Engineers Comments Regarding Surface Water Drainage

Application Reference:	M/40/26/PL	Reviewer Reference:	ADC/EXT5/AF
Planning Officer:	Kathryn Welch	Date of Review:	17/08/2026
Site Name:	Arundel Court 47 Elmer Road Middleton-on-sea PO22 6LB		
Application Description:	Two storey rear extension to enlarge existing flats and additional second floor to building to create an additional 2No. 2 Bed flats giving an overall total of 6No. 2 Bed flats. 6No. parking spaces to the rear consisting of a 3 car garage block and 3 parking bays and associated hardscaping. This application is in CIL zone 4 (zero rated) as flats.		
Assessment Number:	1

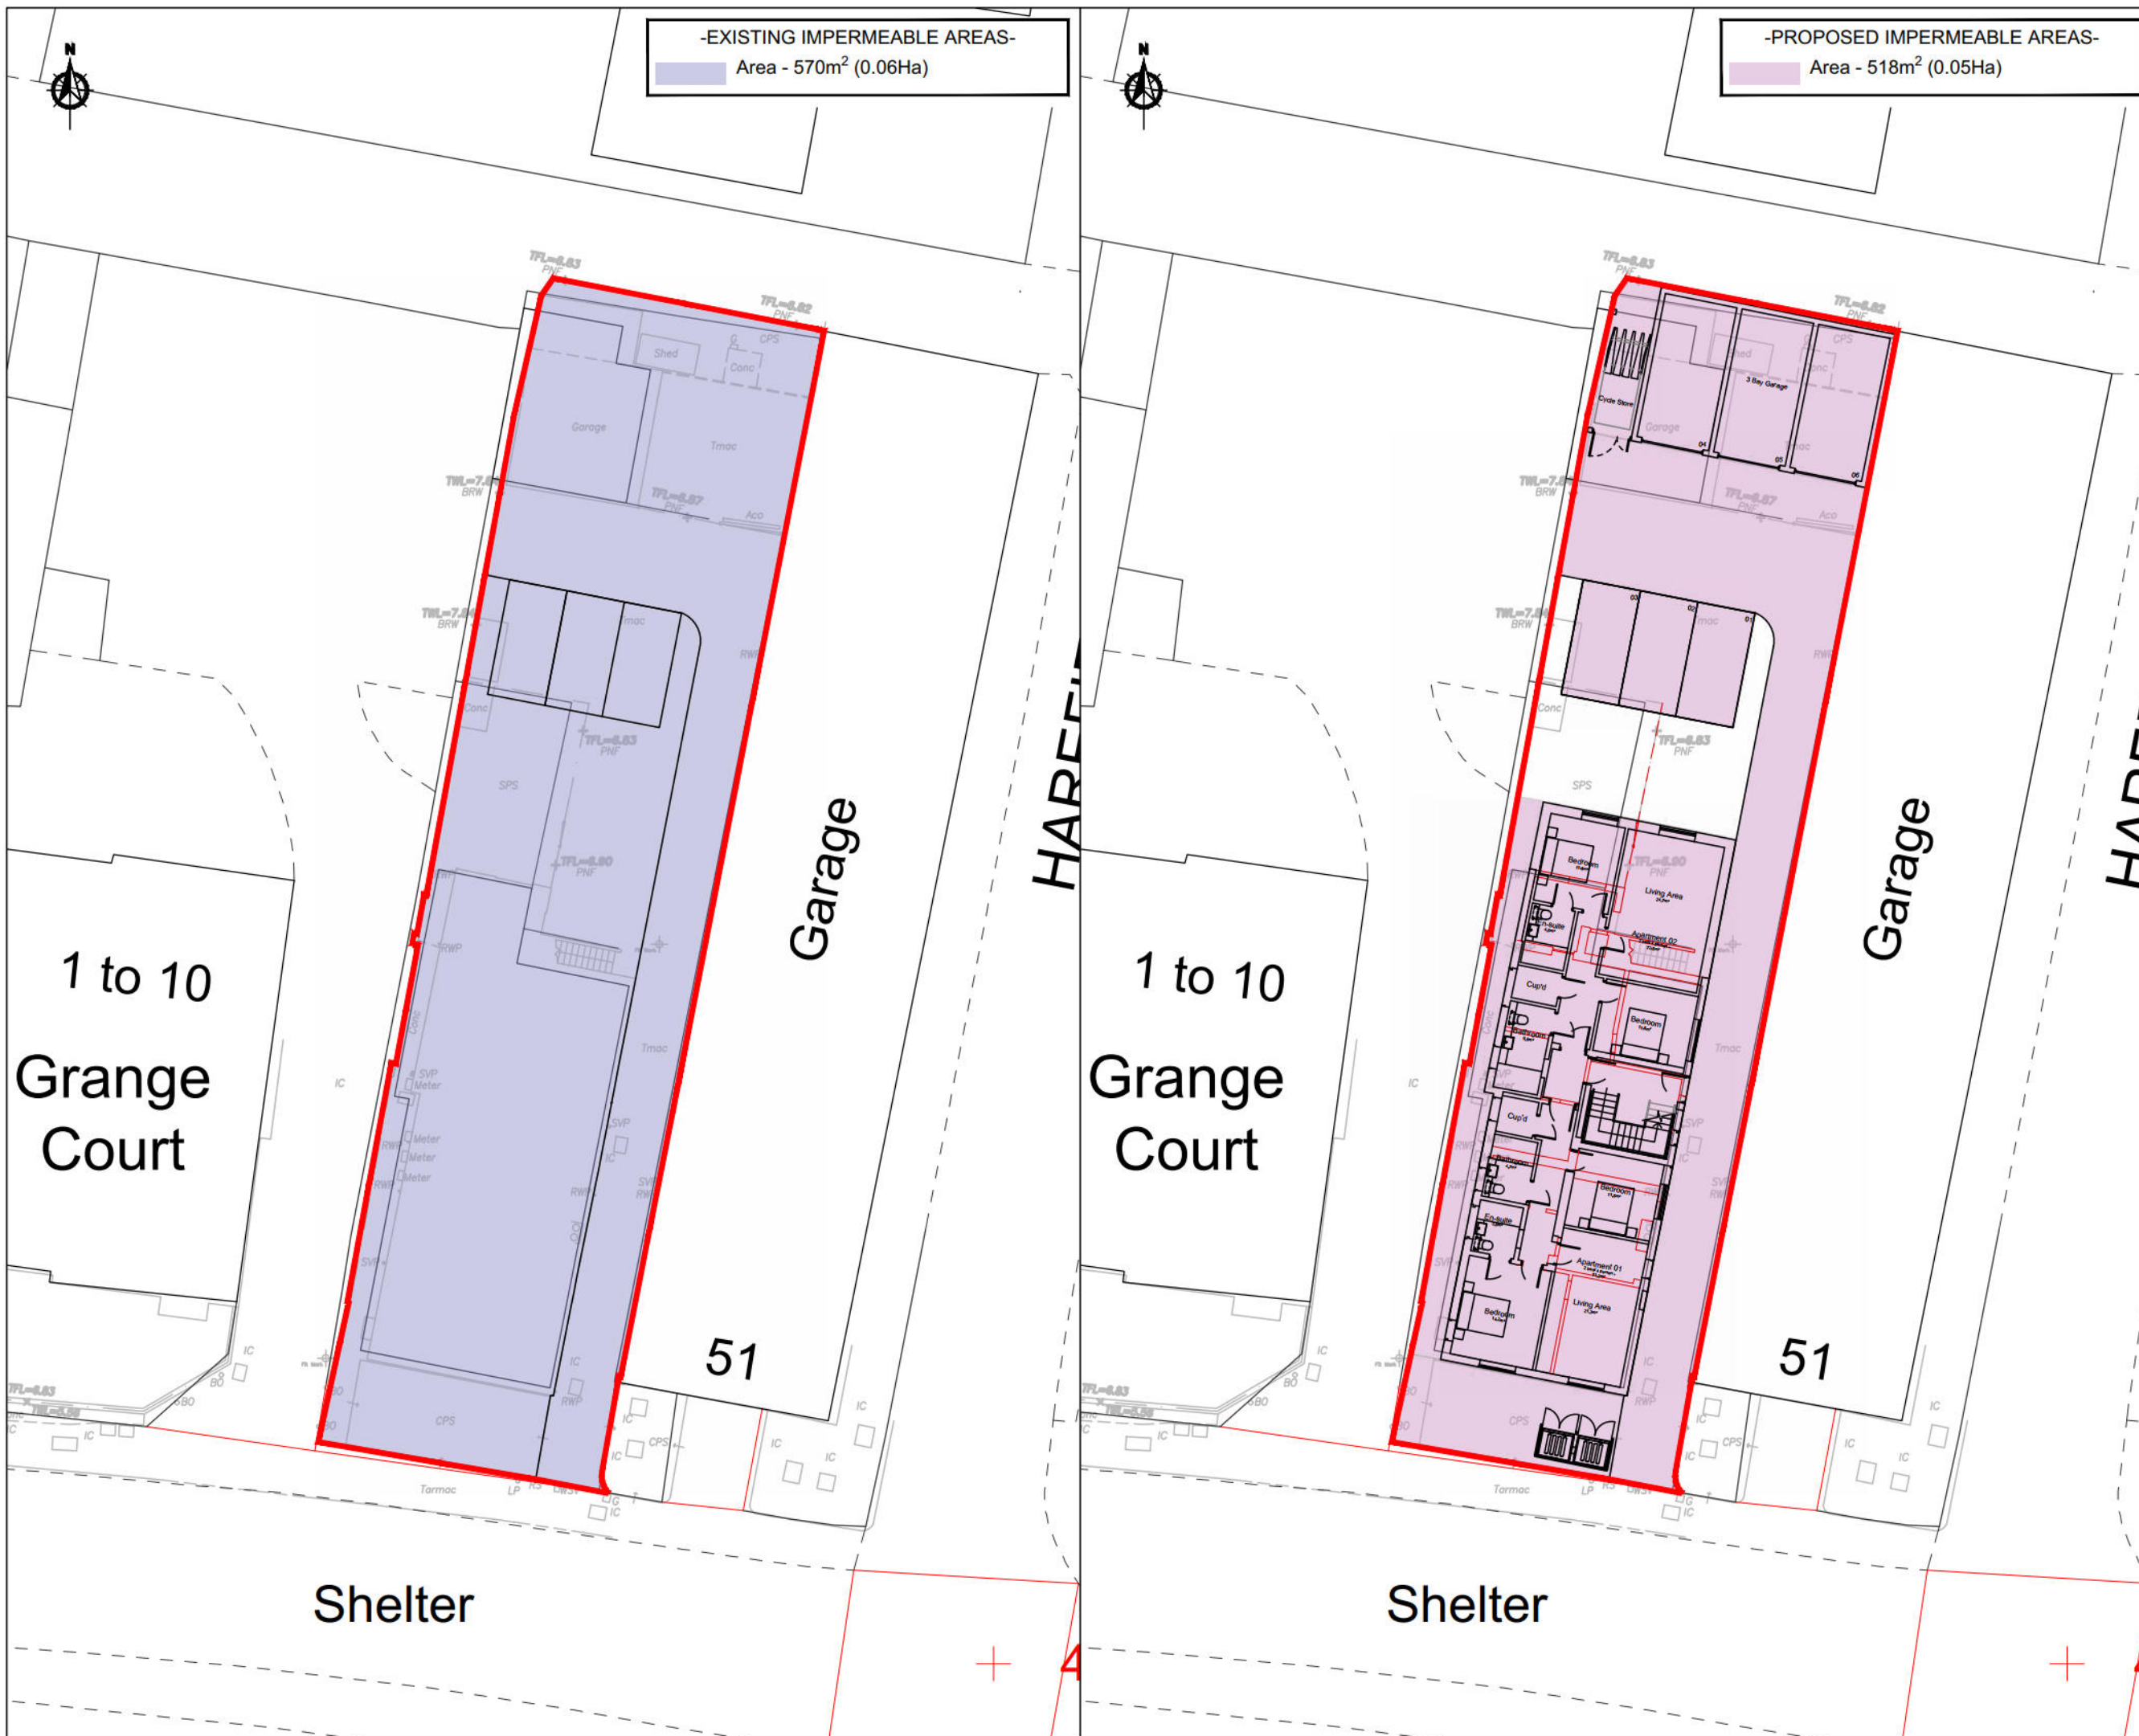
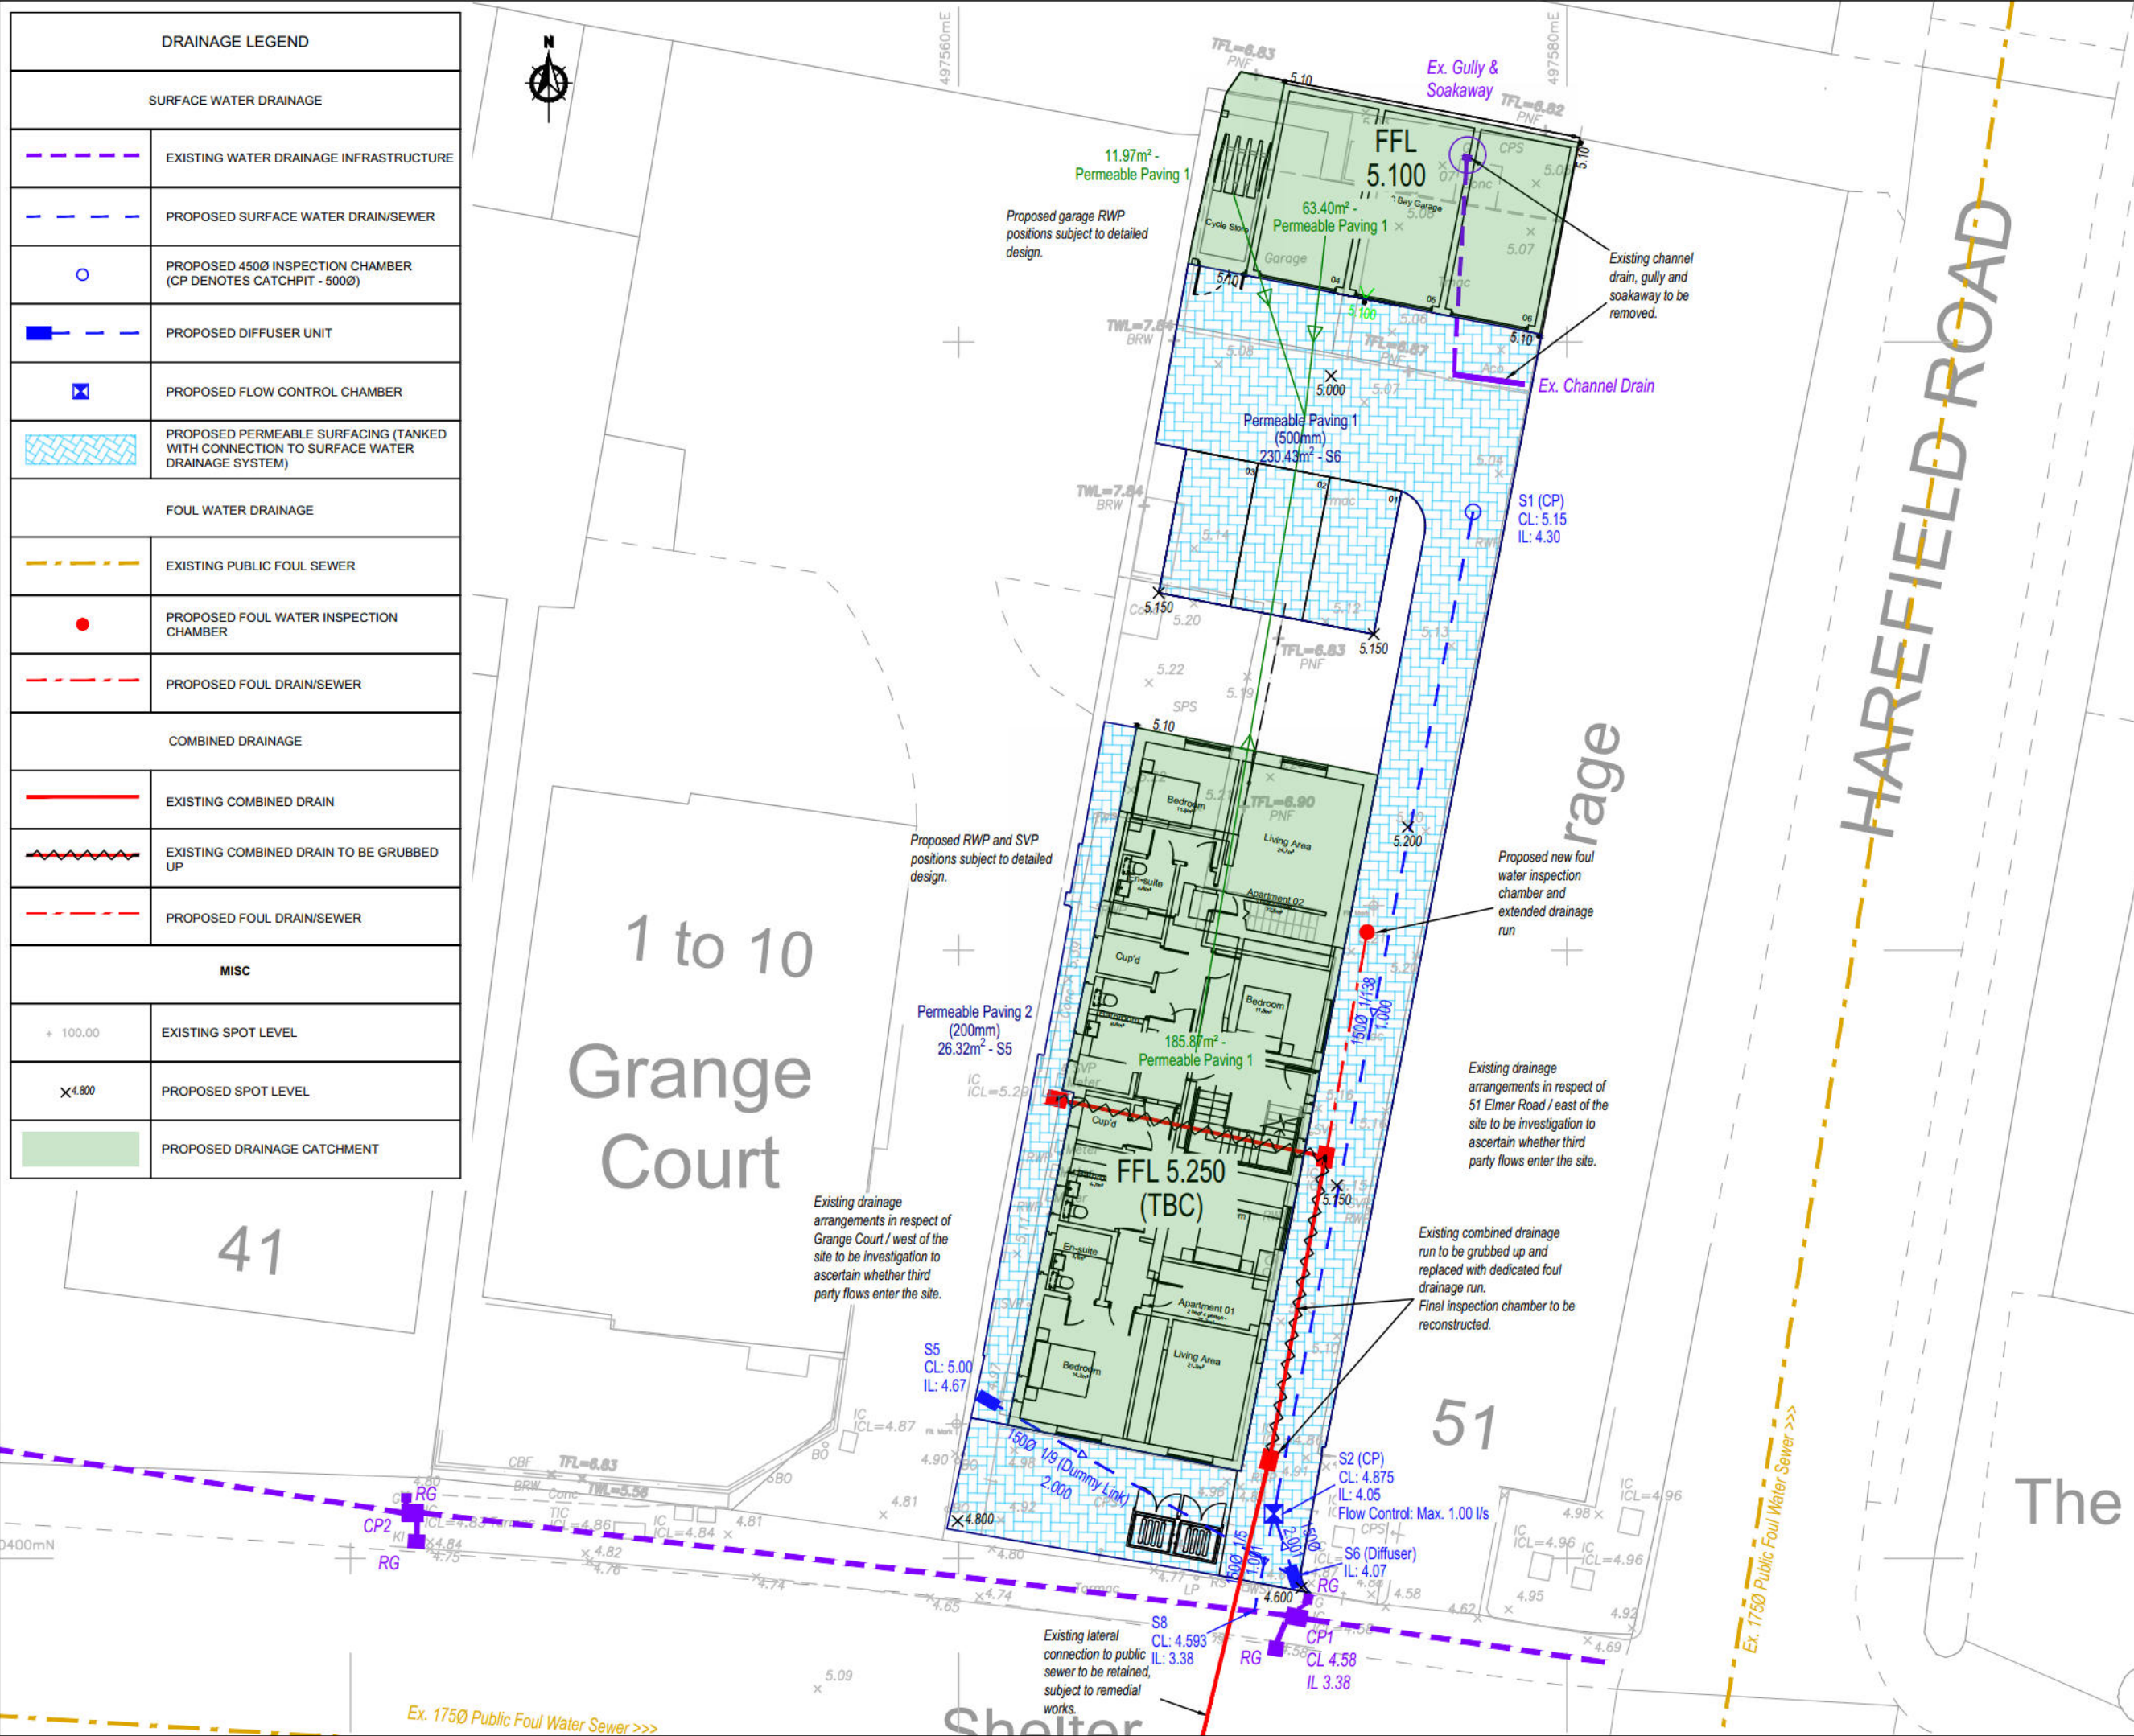
- 5.1. The existing site is developed and entirely impermeable.
- 5.2. The design proposals include permeable paving and may include planters / SuDS Pods although these are not currently shown on the drainage layout plan.
- 5.3. Due to the small scale of the development and use of the site, together with the limited opportunities for incorporating amenity value delivered through the sustainable drainage system, the limited additional multifunctional elements beyond permeable paving and water butts would be proportionate to the nature and scale of development.
- 5.4. The proposed provision to enhance amenity should be clarified and may qualify for a 'small sites' exception.

- 6.1. The report notes SuDS Pods / Planters but these are not shown on the drainage layout plan and the sizes are not known.
- 6.2. The proposed provision to enhance biodiversity should be clarified and may qualify for a 'small sites' exception and not require assessment by an Ecologist.
